Ref: 6/2022/1657/HOUSE
Date: 13/08/2022

HISTORIC BUILDINGS AND CONSERVATION ADVICE

RE: 159 Parkway, Welwyn Garden City, AL8 6JA

The application is for the construction of two rear dormers and two front rooflights to facilitate the conversion of the loft to habitable space.

6 Proposed Front Elevation
1 : 100

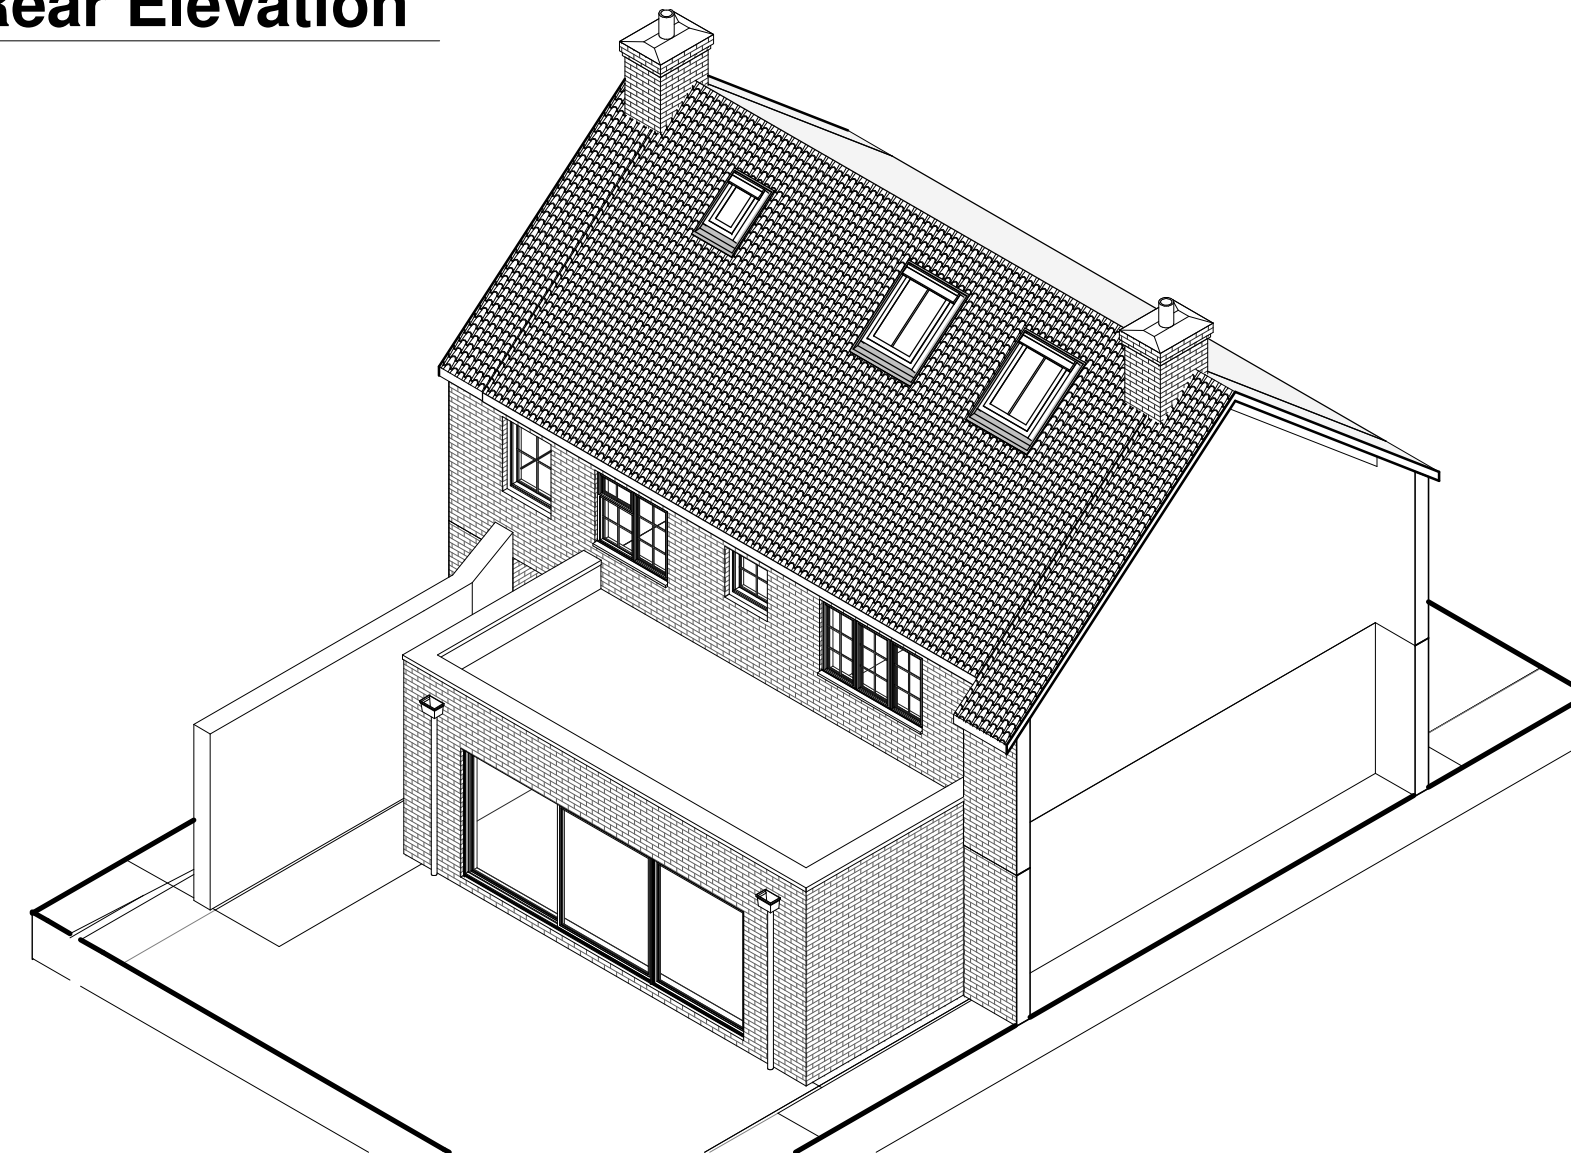
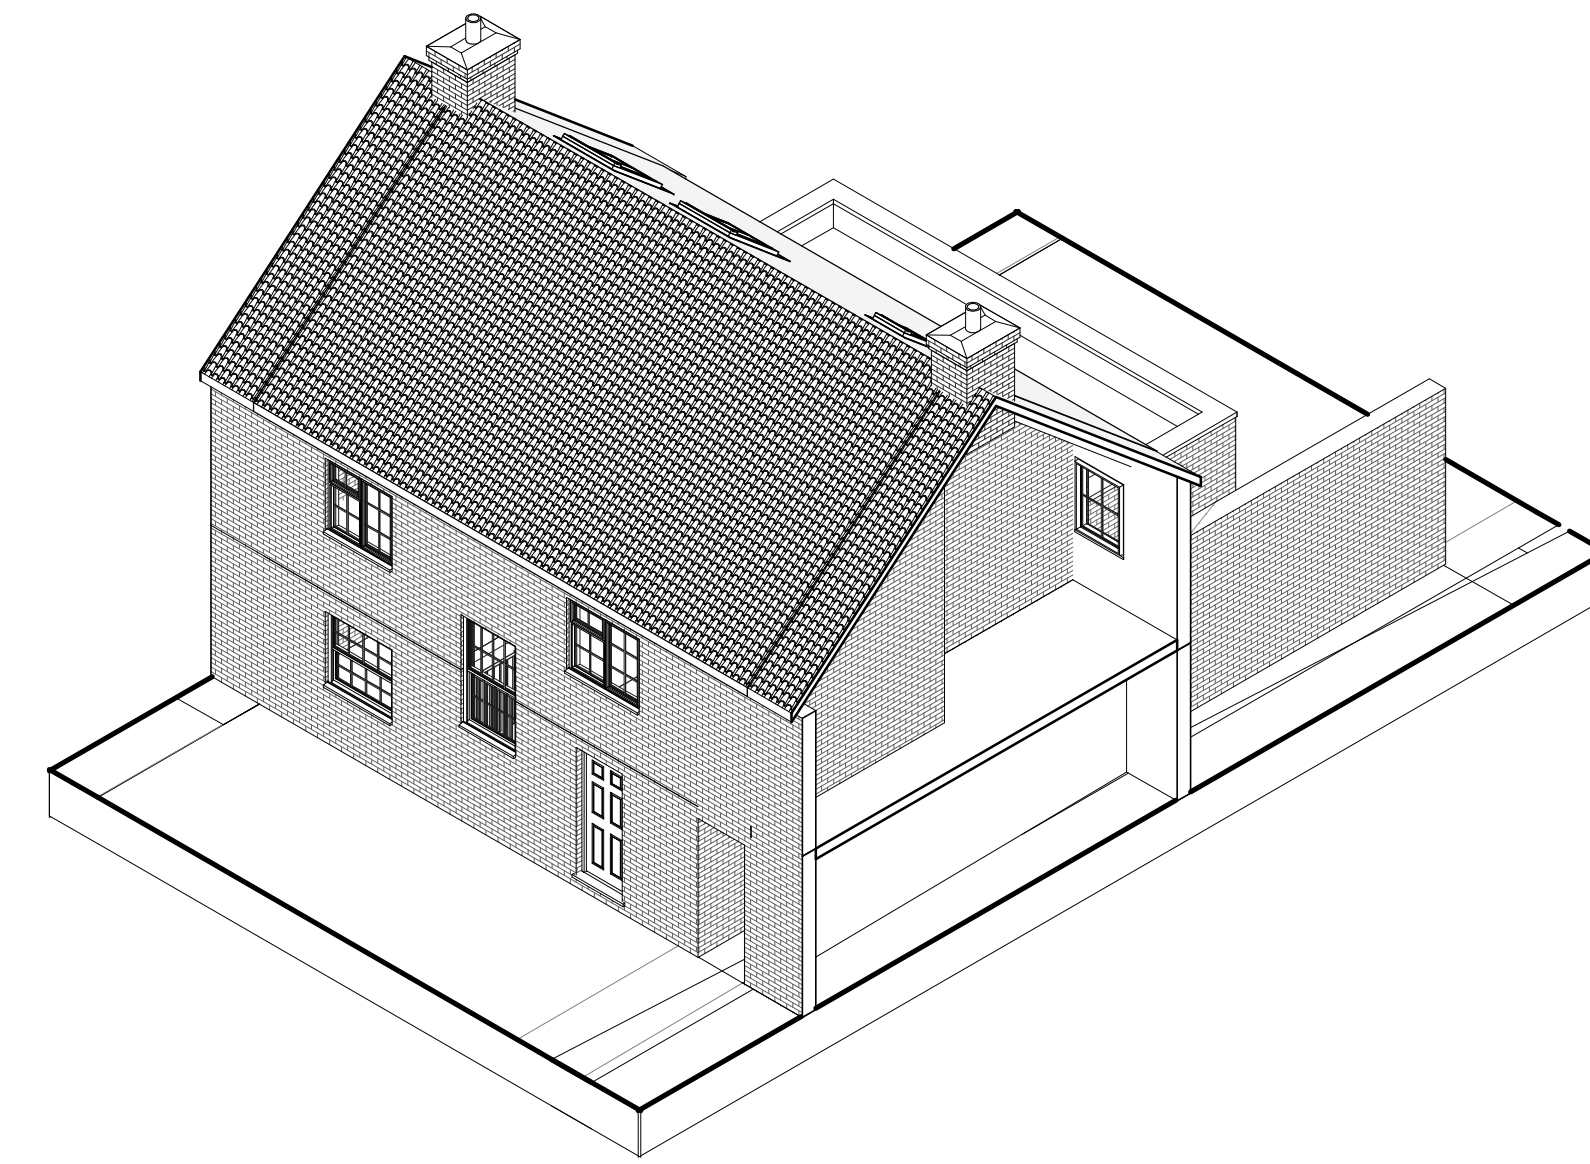
An objection is raised as the proposed rooflights and dormers detract from the uniformity and largely uninterrupted appearance of the roofscape of the terrace and the contribution it makes to the streetscape. The addition of these features undermines the character and appearance of the building and this part of the Conservation Area. Whilst the dormers are not visible from Parkway, the rear roof slope appears to be visible from Stanborough Close and, in any case, a lack of visibility from public areas does not equate to a lack of harm as the rears of buildings are seen from neighbouring gardens which are also within the Conservation Area. Dormers would be an incongruous feature to the terrace and the front rooflights are an unsympathetic addition to the streetscene.
